April 2, 2024

Re: **Kendall Auto Group Auto Storage Yard - PA 23020**
IECO No. 20-1092

The project referenced above is revised in response to the review comments dated February 23, 2024. The review comments are numbered on the letter and have been addressed in *italics* as follows:

STREET LIGHTING POWER & PHOTOMETRIC PLAN & SCHEDULES

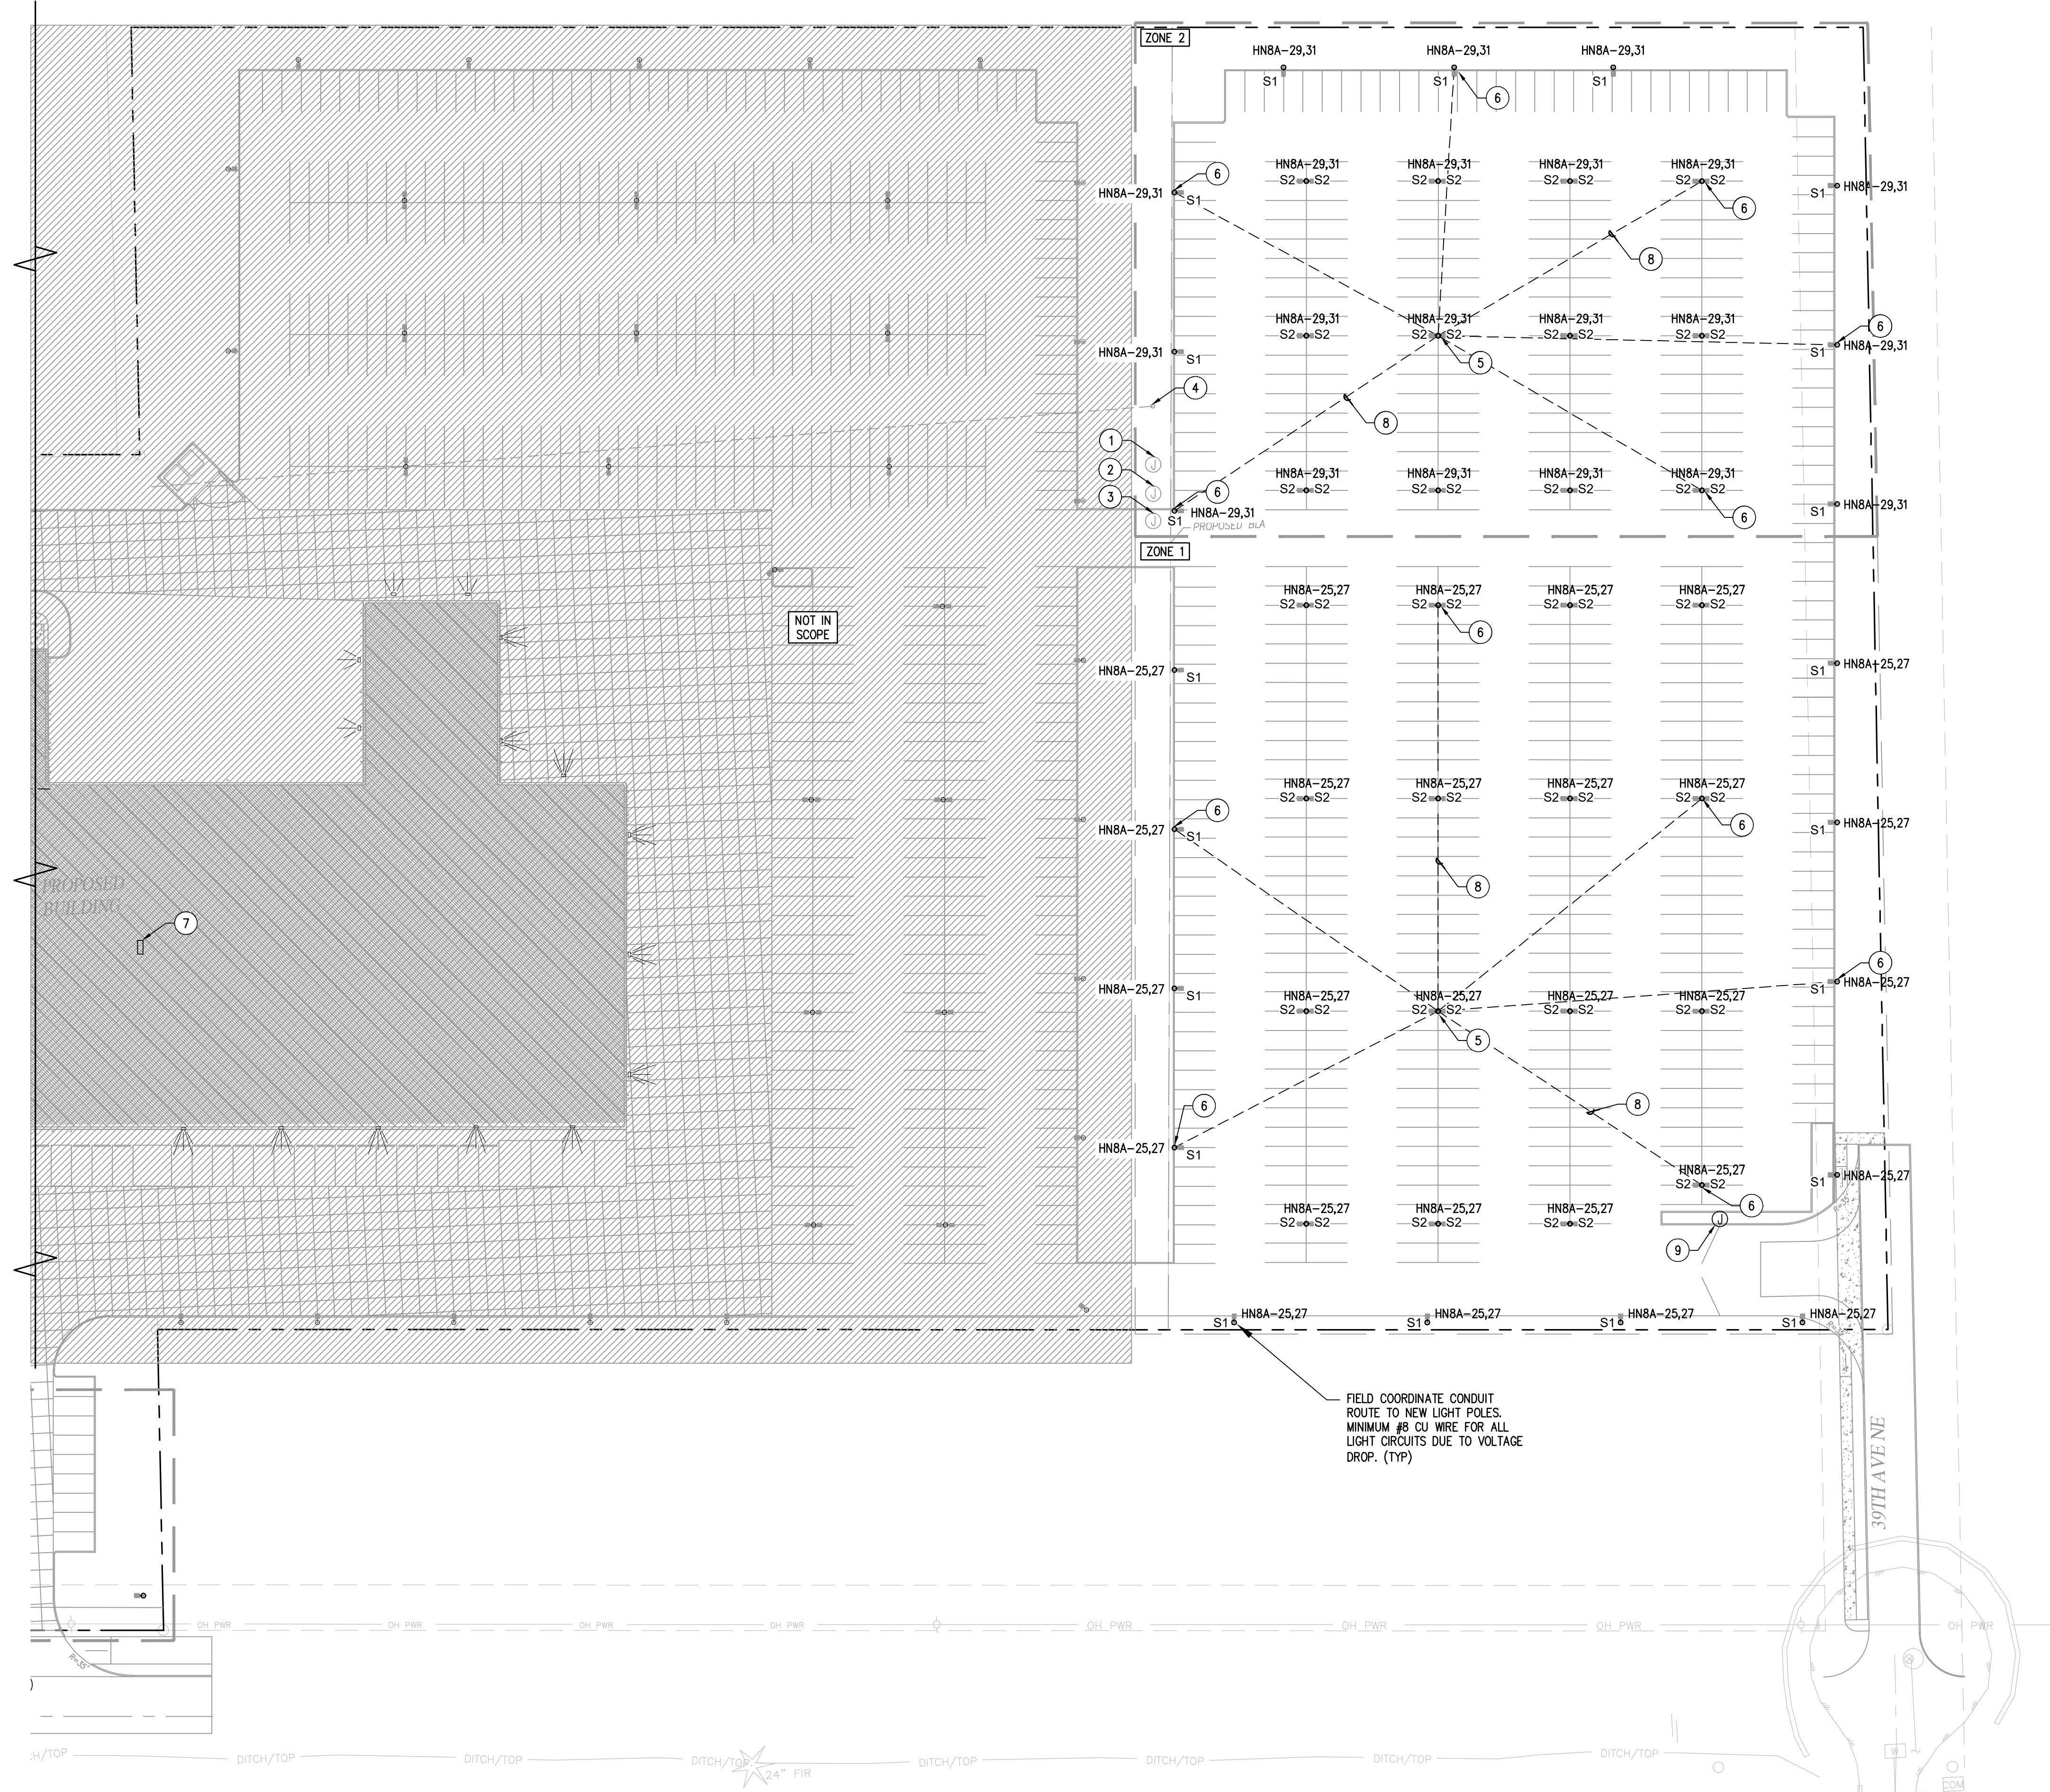
19. Per EDDS 3-506, street lighting will be required.
- a. 39th Ave NE street lighting layout shall be designed as a Collector Arterial.
 - i. Designed LED street lighting should be PUD owned/maintained fiberglass pole type with City responsible for utility bills.
 - ii. Street lights provided shall be 200 watt equivalent LED street lights.
 - iii. Spacing of fixtures should be approximately 150'-200'
 - iv. As part of civil construction approval proposed PUD street lighting locations shall be submitted to the City for review/approval.
 - v. Contact Eddie Haugen of Snohomish County PUD at (425) 783-8276 or wehaugen@snopud.com for more information regarding PUD design.

PUD is currently working on the plan and it will be submitted to the city as soon as it is done.

DRAWING TITLE:  
**LANDSCAPE PLAN**

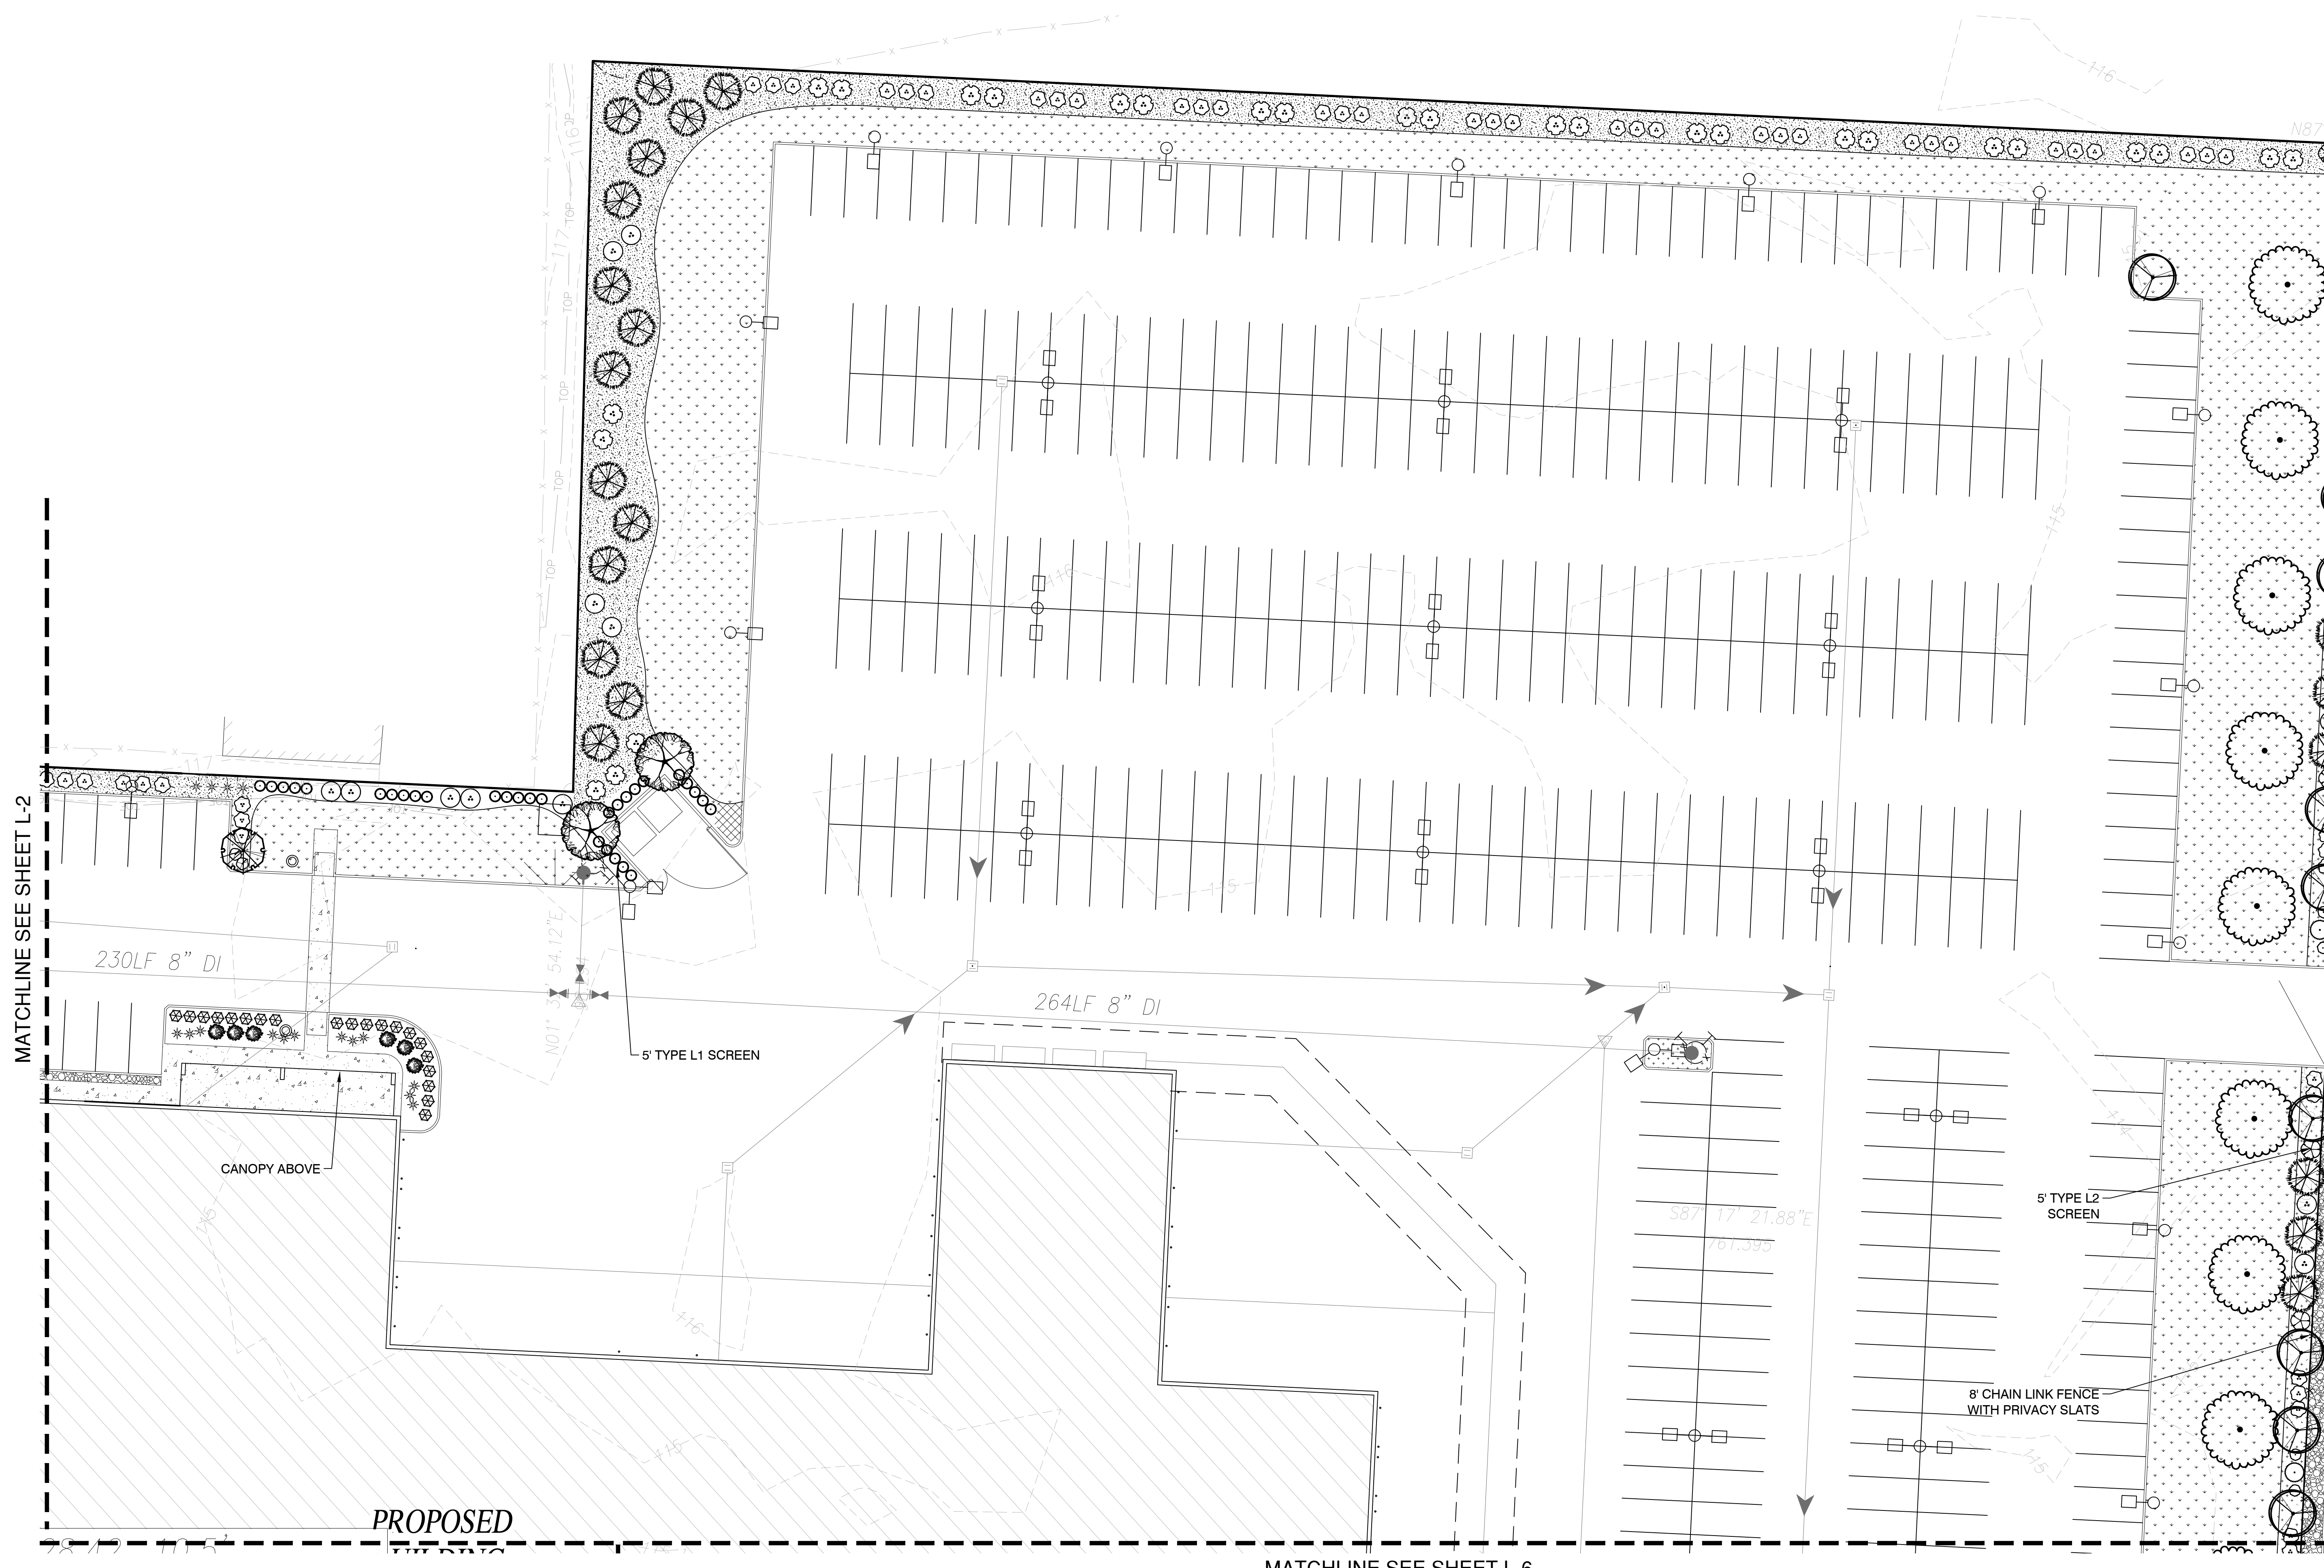
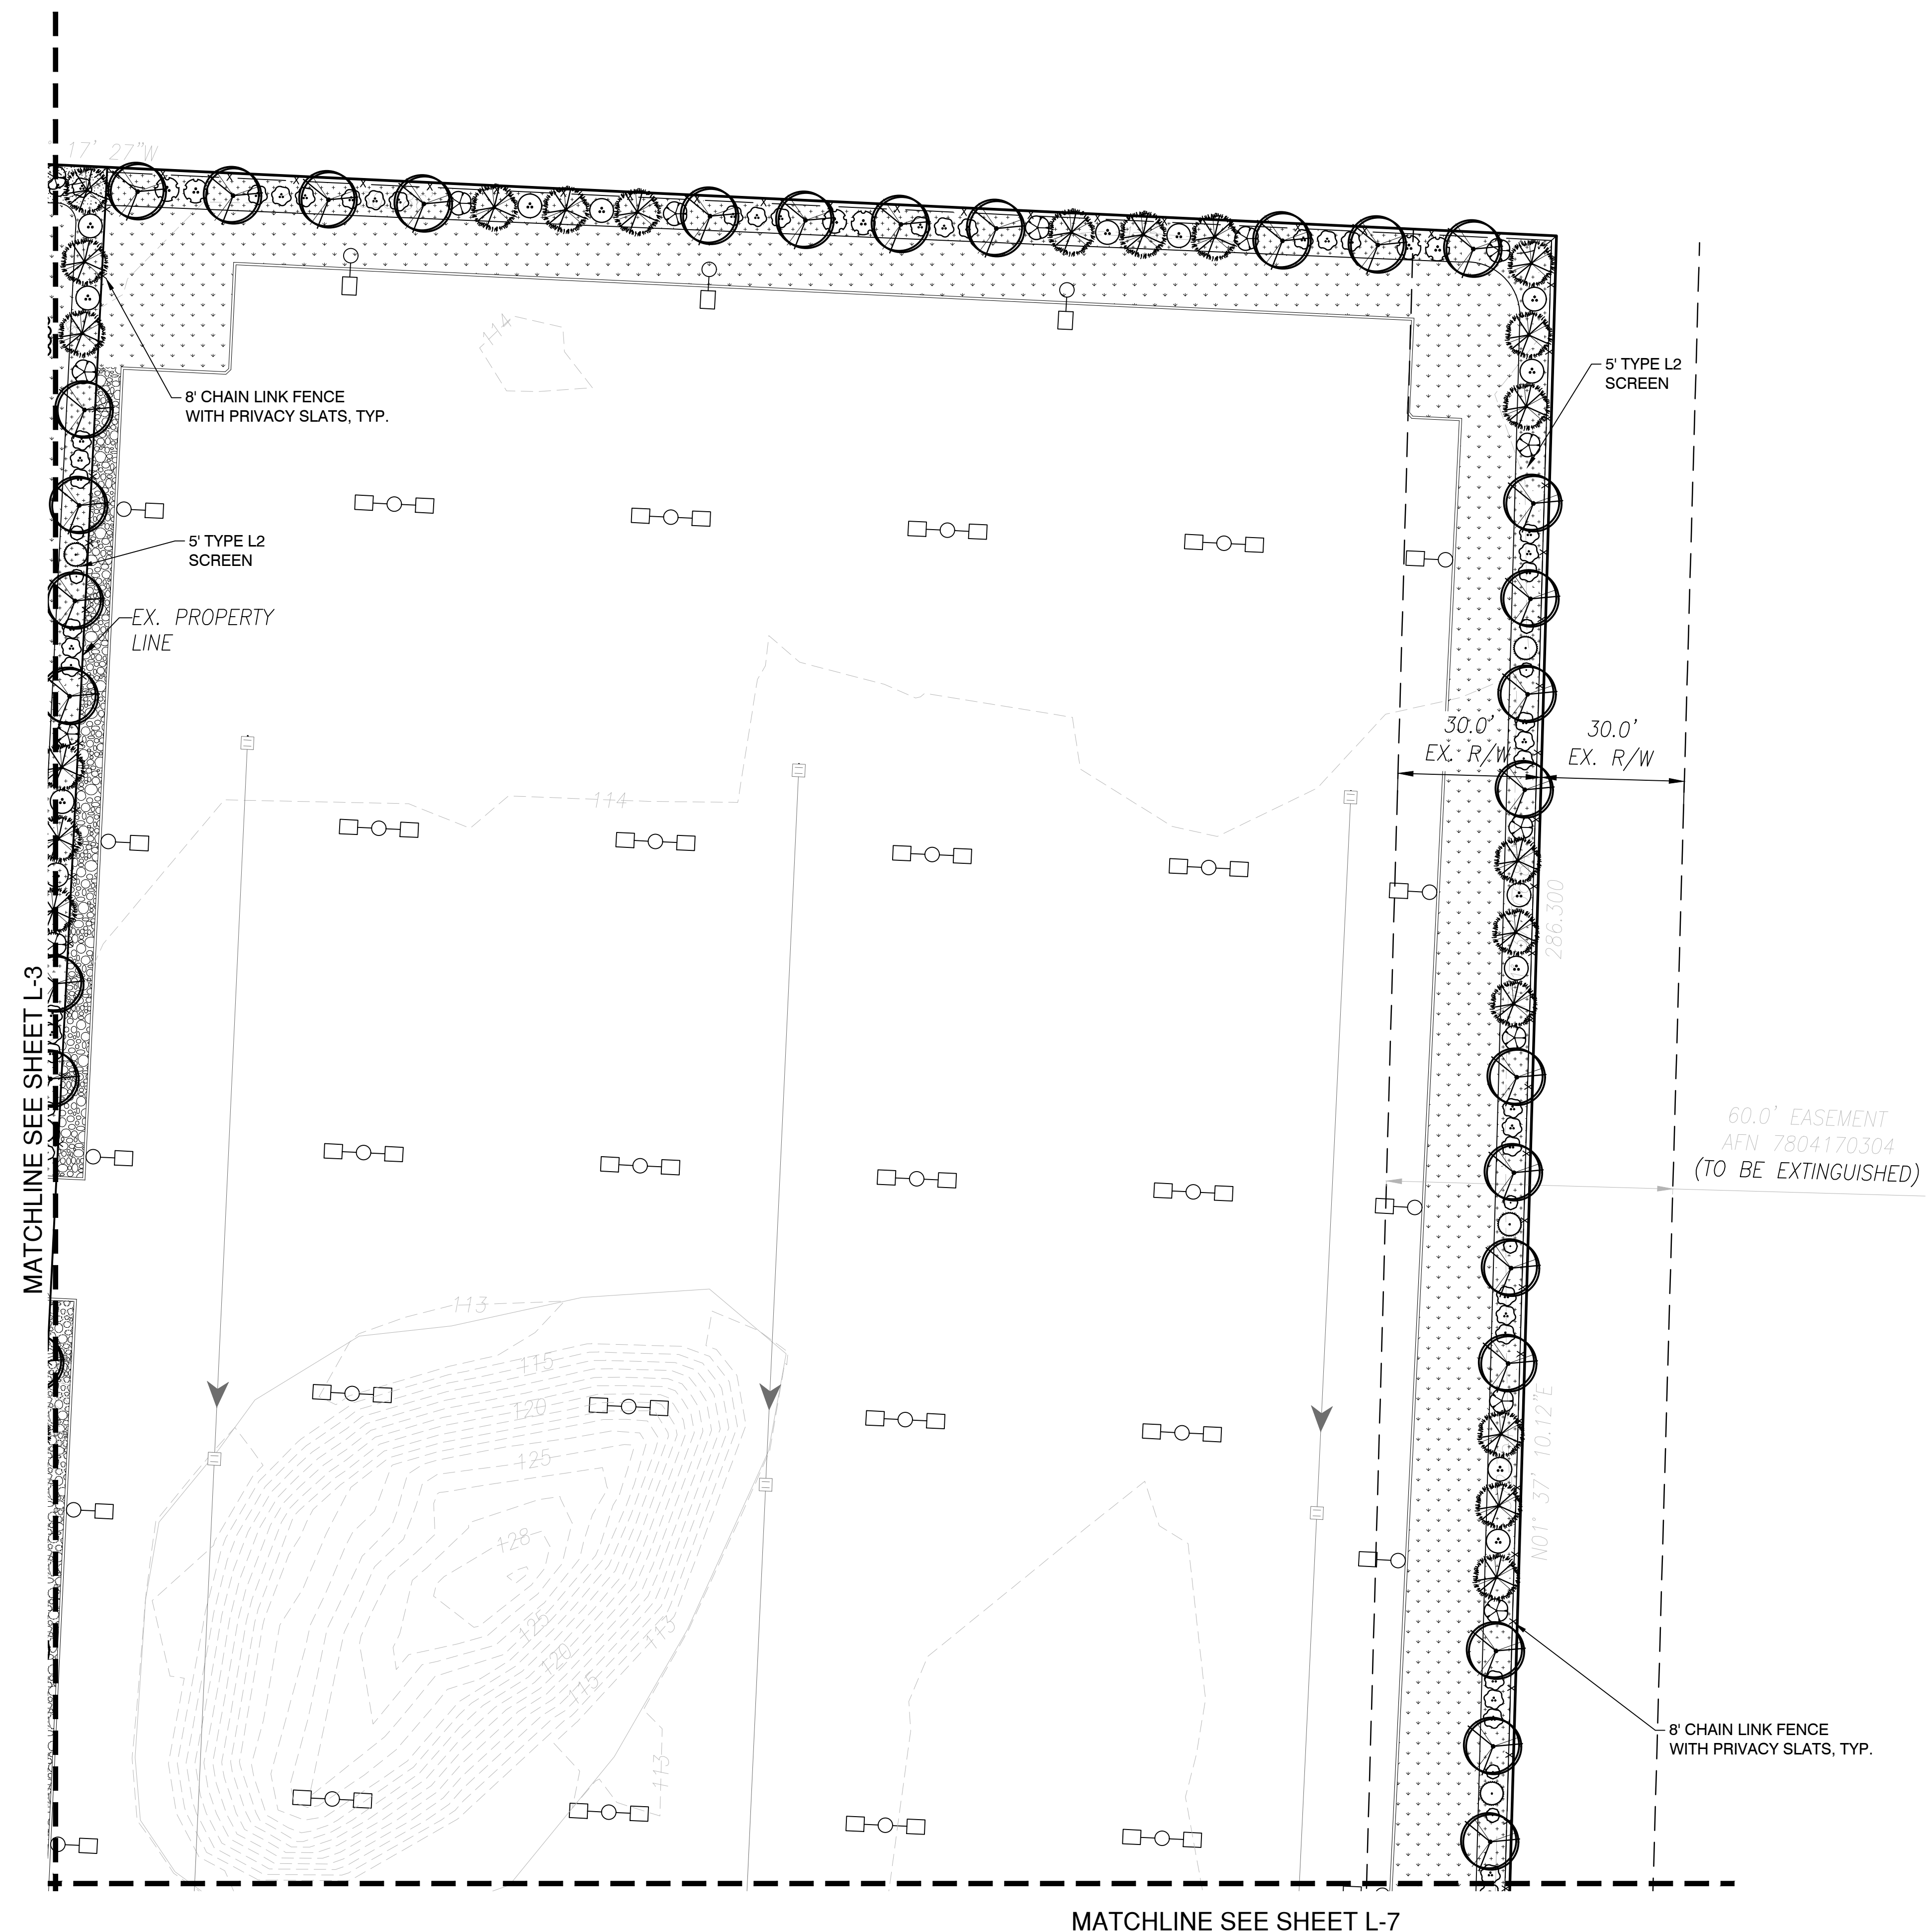
4. The landscape plan will need to be amended to provide a minimum 5 foot L1 landscape buffer shall be required around the perimeter of the storage yard, or a 6 foot-high solid masonry wall or sight-obscuring fence 5 feet inside the property line with an L2 landscape buffer. The existing landscape buffer on the Subaru Auto Dealership site does not meet the L1 or L2 landscape buffer requirements.

Please see the revised landscape plan with the revised plantings on the west side of the project.
